Submission for State Significance Development - SSD 17- 8699

**Greenwich Hospital
97-115 River Road, Greenwich, 2065
Lane Cove Municipal Council**

Image 6: Cross Section through the Hospital

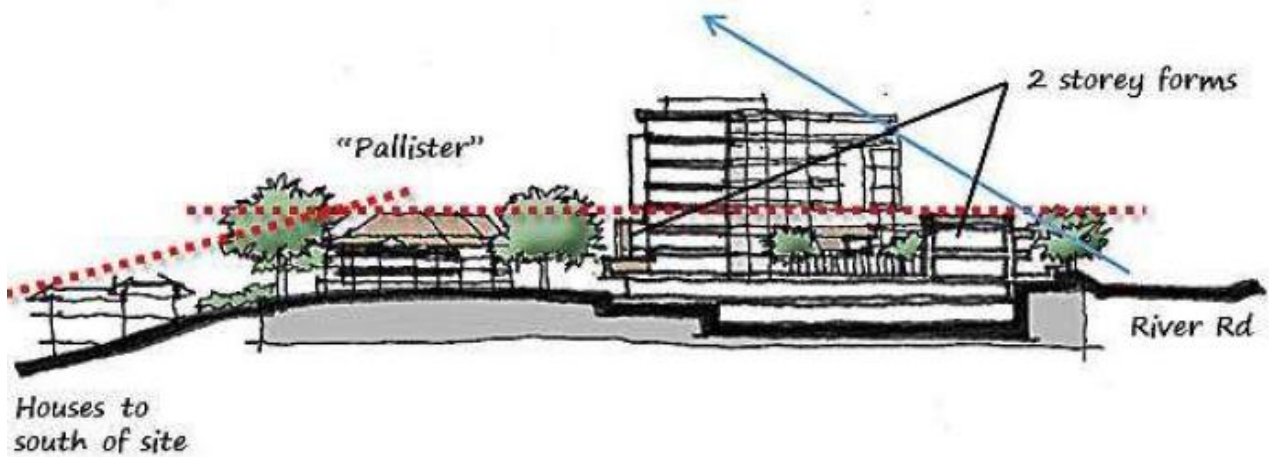
This development alters the context of Pallister House by creating a denser built to the extent that Pallister House cannot be clearly understood and interpreted as a former substantial Victorian residence. The bulk, height and mass of the contemporary character of the architectural design of the towers and Villas mean that the Victorian character of the heritage item cannot be appreciated as an earlier form with the significance of the 1892 Victorian Gentlemen's residence.

The increase in density from the proposed development to the northern and western portions of the site will alter the visual setting of Pallister and will invariably alter the architectural fabric, form and character of the 1892 Victorian Gentlemen's residence. The apartment buildings do alter the understanding of the primary frontage of Pallister House and its setting and infringe on the curtilage of the heritage building. The southern apartment building is visible in views of Pallister from the access road approach off St Vincents Road. Views of the apartment building to the rear of Pallister do result in increasing the extent of built form included in views of the house from the east; they do interrupt an appreciation of the form, scale or character of the heritage item.

Figure 39 - Section demonstrating the relationship between the proposed Seniors Living Villas and Pallister, with the proposed villas sitting below the existing tree canopy. (Source: Bickerton Masters Architects)

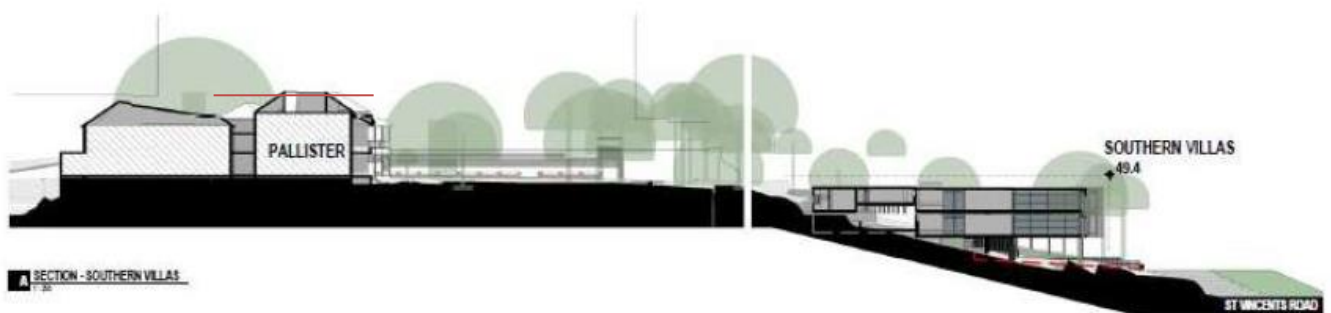
The picture shows Pallister House heritage item in relation to the tall buildings towers that dominate and overpower Pallister House.
